A30 Chiverton to Carland Cross TR010026

8.24 REQUEST FOR NON-MATERIAL AMENDMENTS TO THE DRAFT DCO

June 2019

Drawing file: TR010026 / TR010026-000262-6.3 ENVIRONMENTAL STATEMENT FIGURE 7.6 ENVIRONMENTAL MASTERPLANS, SHEET 18.pdf

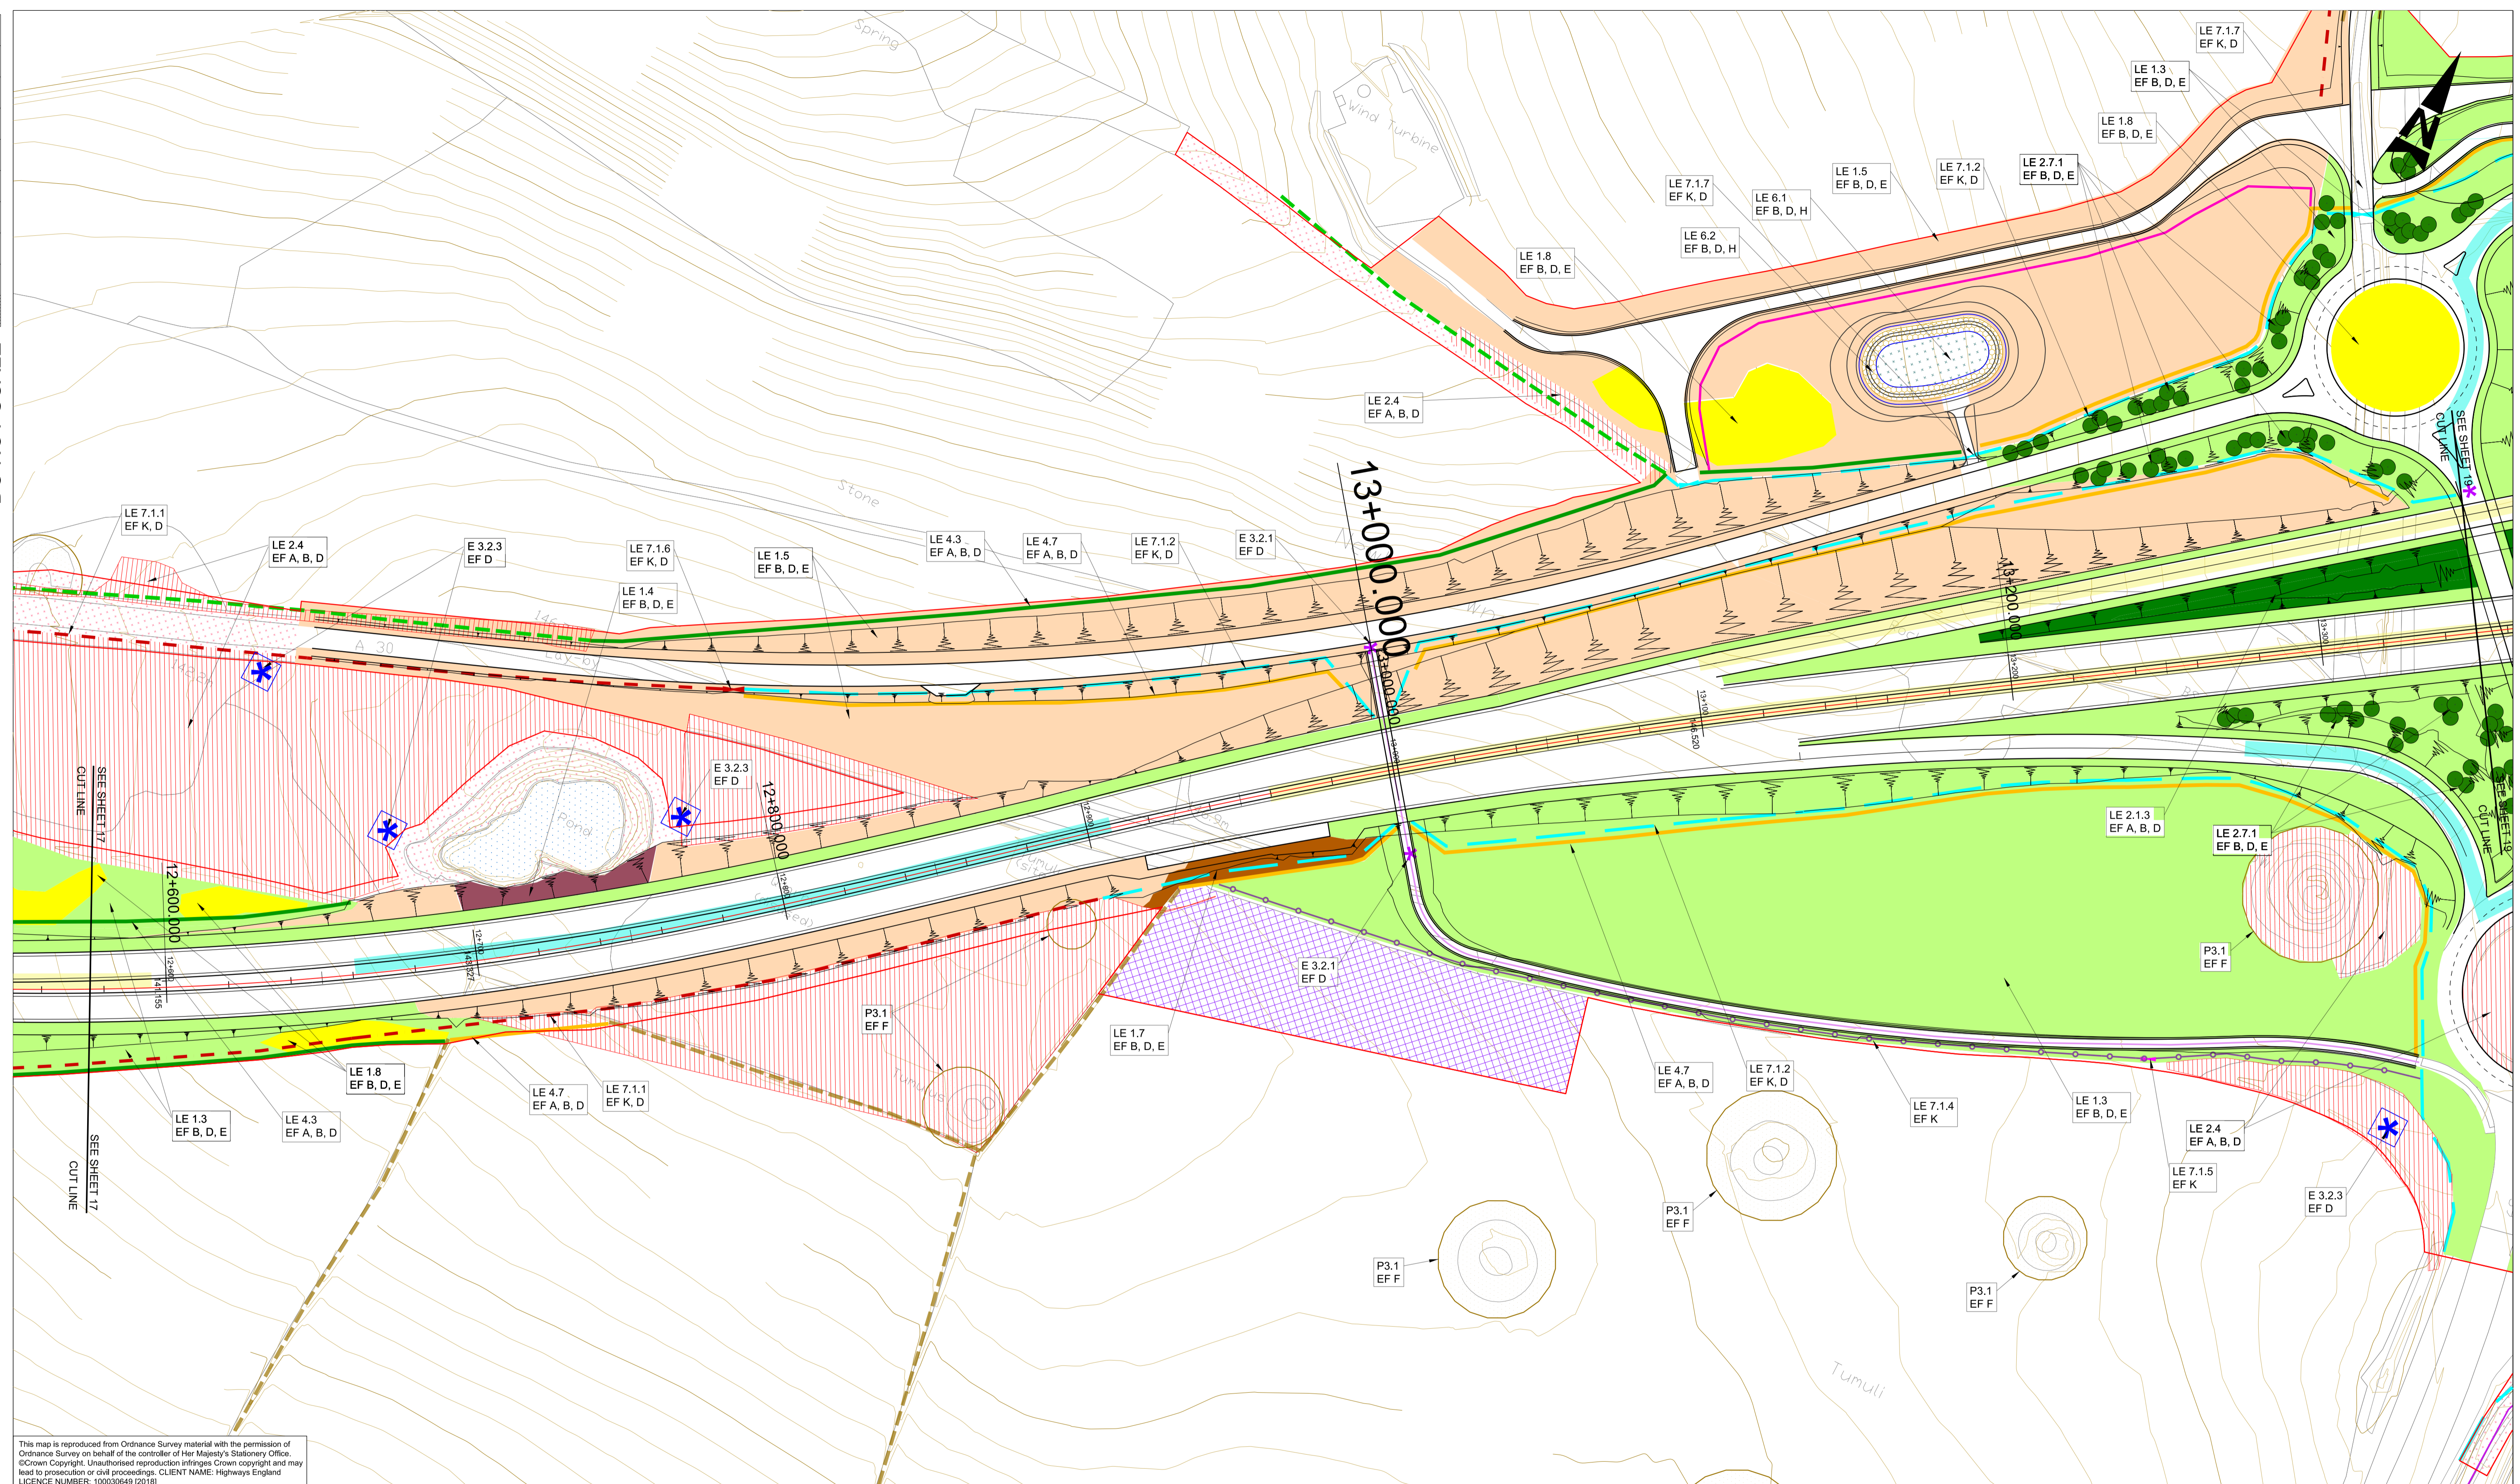
- 1.2.2 In response to this, Highways England propose an amendment to the **dDCO** (Document Reference 3.1(E)) and associated documents and plans to provide an elevated viewing area. Highways England also propose a new footpath PR16, which would be 90m in length and connect footpath UU to the southern section of the existing open space land.

- 1.2.3 The proposed elevated viewing area refers to a triangle of land to the west of proposed footpath UU and to the north of proposed footpath PR16. It is shown on Sheet 18 of **Figure 7.6 Environmental Masterplans** (Document Reference 7.6(B)). The area includes a raised viewing area which would be elevated to a height of up to 1.2m to match the height of the adjacent Cornish hedge. The raised area will be a small area in the western point of the triangle of land denoted by a pink star shape on Sheet 18 of **Figure 7.6 Environmental Masterplans** (Document Reference 7.6(B)).

- 1.2.19 As such, the addition of the elevated viewing area and footpath to open space land shown on Sheet 18 of **Figure 7.6 Environmental Masterplans** (Document Reference 7.6(B)), would not change the results of the assessment of landscape and visual effects as reported in **Chapter 7 Landscape** or **Chapter 8 Ecology and Nature Conservation** of the Environmental Statement (Document Reference 6.2) [APP-060; APP-061].

Drawing file: TR010026 / TR010026-000263-6.3 ENVIRONMENTAL STATEMENT FIGURE 7.6 ENVIRONMENTAL MASTERPLANS, SHEET 19.pdf

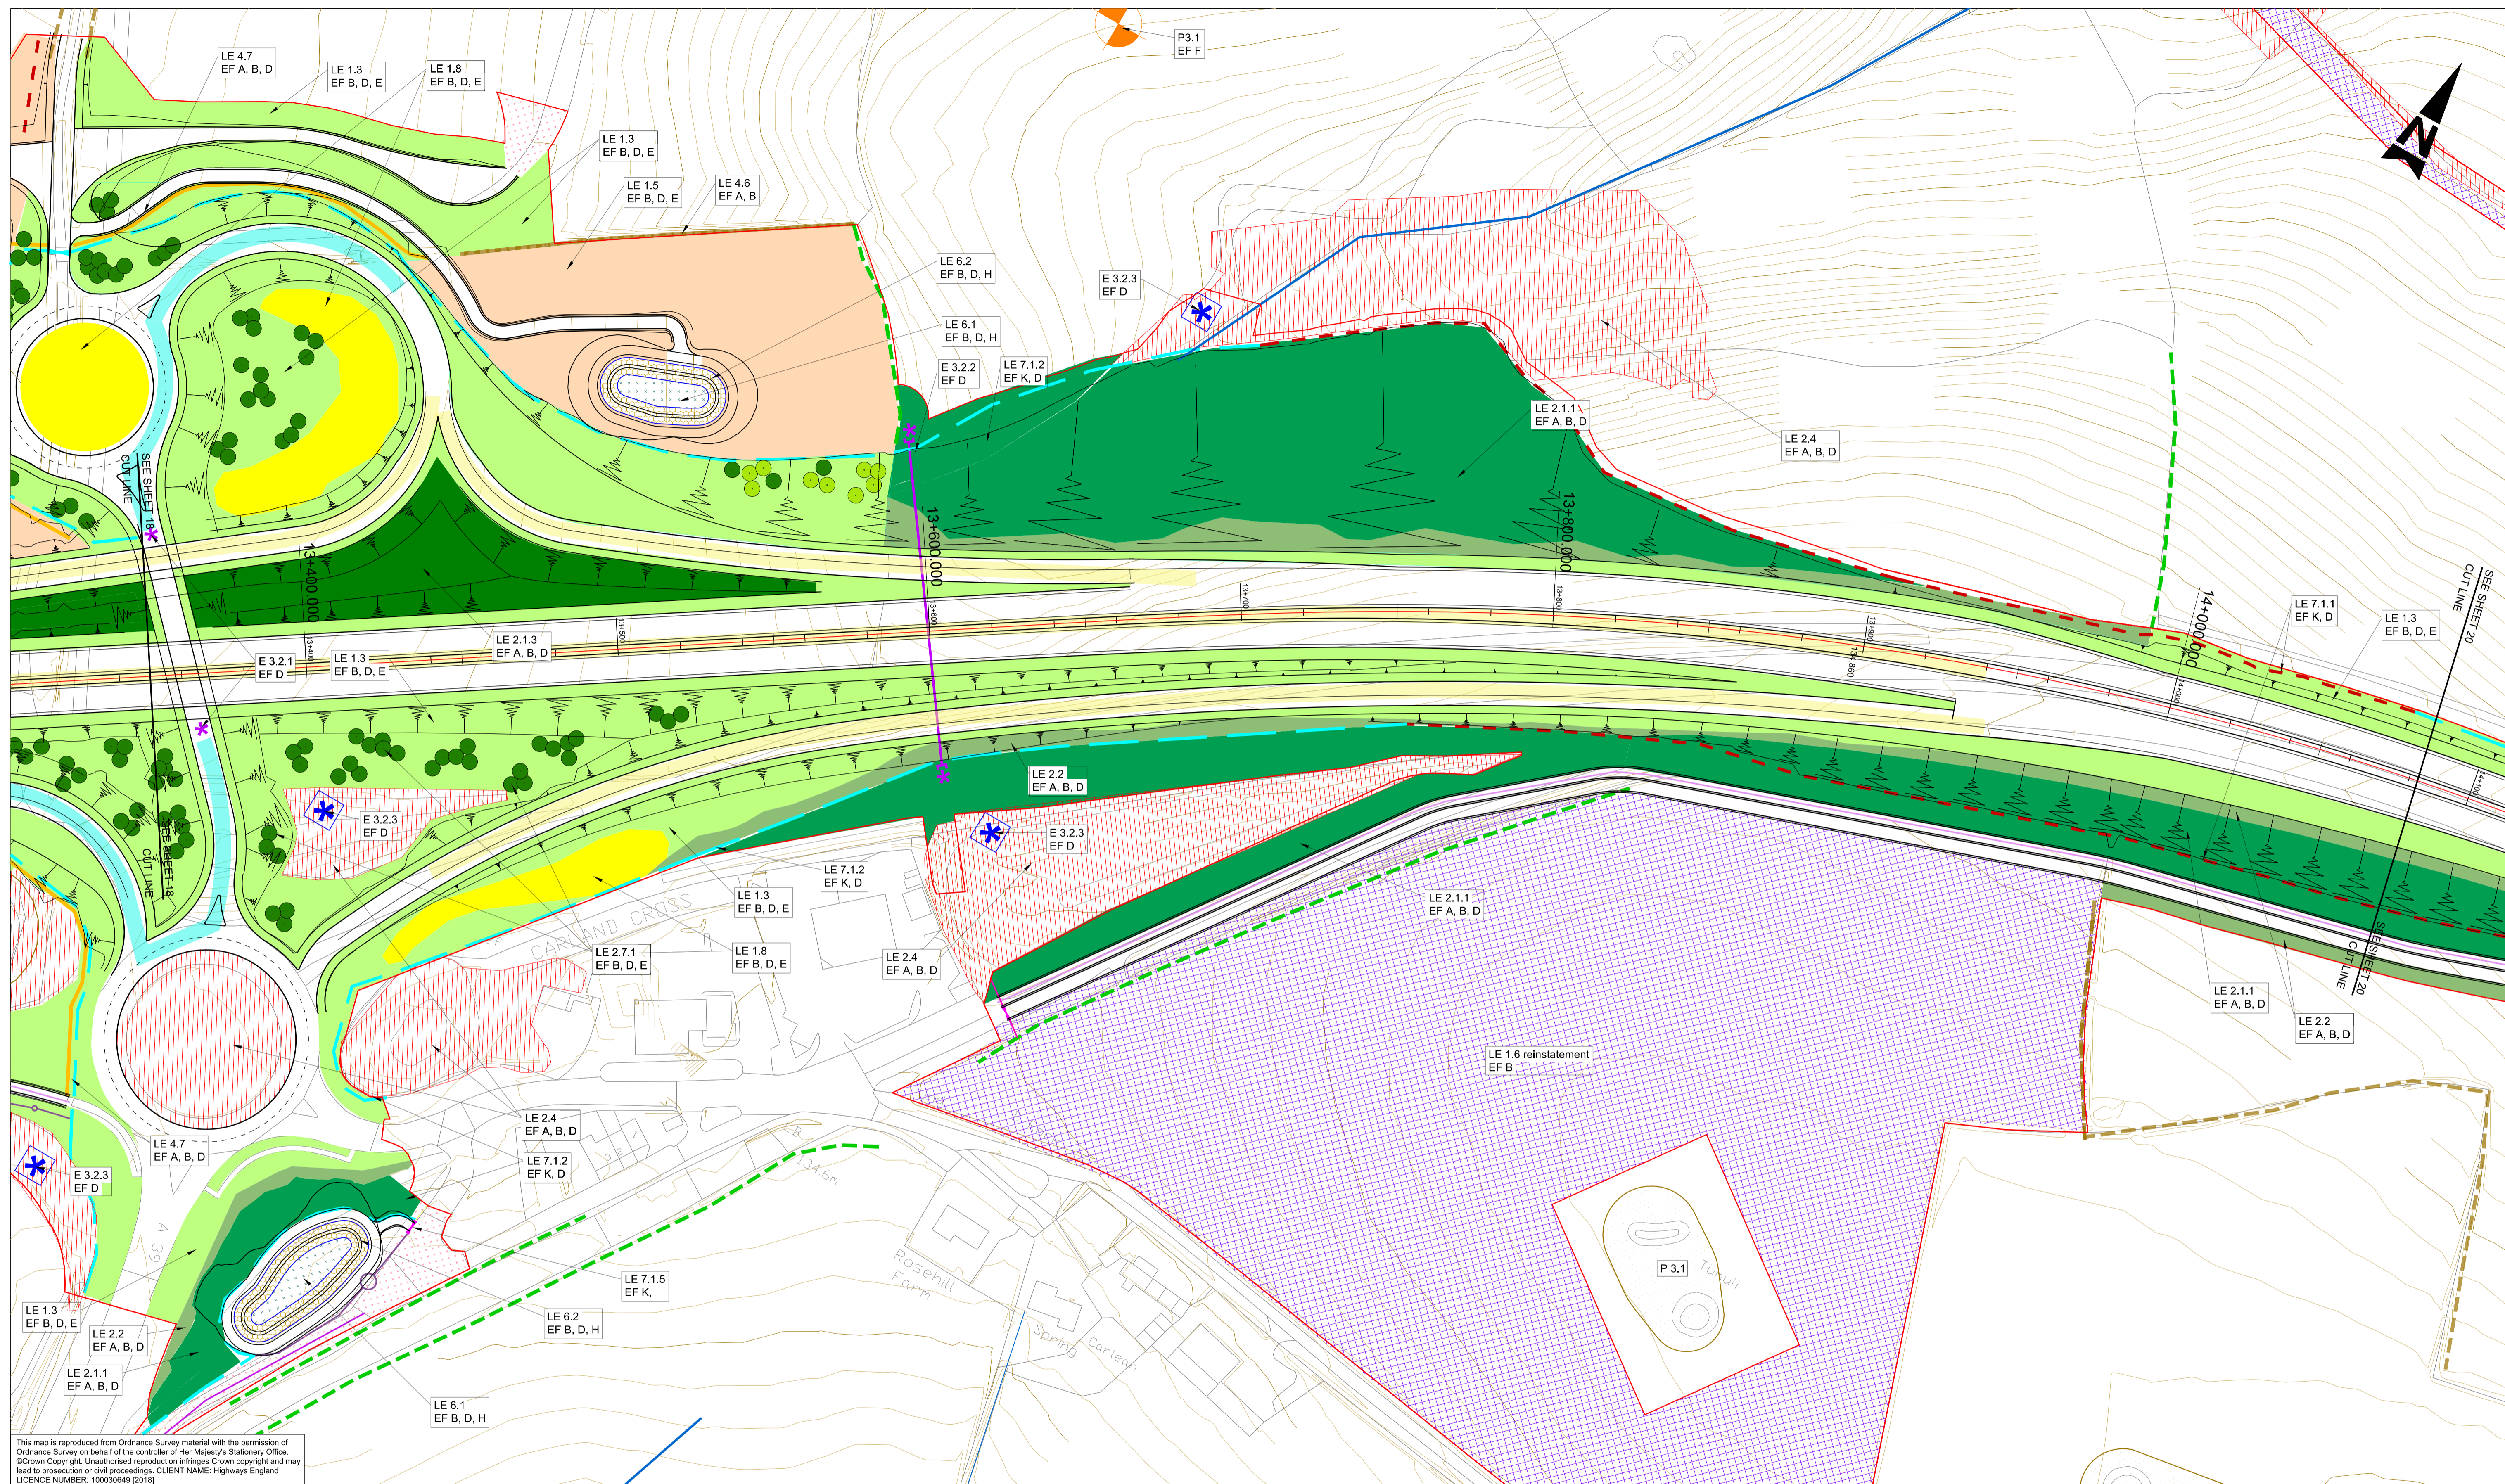
- 1.3.3 In order to provide access for walkers, cyclists and horse riders from Carland Cross to Mitchell, Highways England proposes an amendment to the **dDCO** (Document Reference 3.1(D)) [REP3-007] and associated documents and plans to realign Bridleway VV as shown on Sheet 8 of the **Rights of Way and Access Plans** (Document Reference 2.5(C)) and Sheet 19 of **Figure 7.6 Environmental Masterplans** (Document Reference 7.6(B)).

- 1.3.4 The proposed amendment would realign Bridleway VV to the north of its previous position from a point around Chainage 13+850 to Carland Cross. It runs along the northern boundary of the vegetation to be retained, the Toyota Garage and the Carland Cross services station. It turns south adjacent to the southern roundabout of the proposed Carland Cross junction.

- 1.3.5 The proposed realignment meets the existing highway at the junction of Carland Cross and the entrance to the service station access road, opposite the proposed Bridleway UU, and includes a holding area for horses at this location.

- 1.3.15 The Bridleway has been realigned to be as close as possible to the boundary of the Toyota Garage and Carland Cross service station, to retain the proposed areas for landscape and ecology mitigation as far as possible. It has been designed to avoid the areas of vegetation to be retained to the west of Carland Cross service station and to the east of the Toyota Garage.
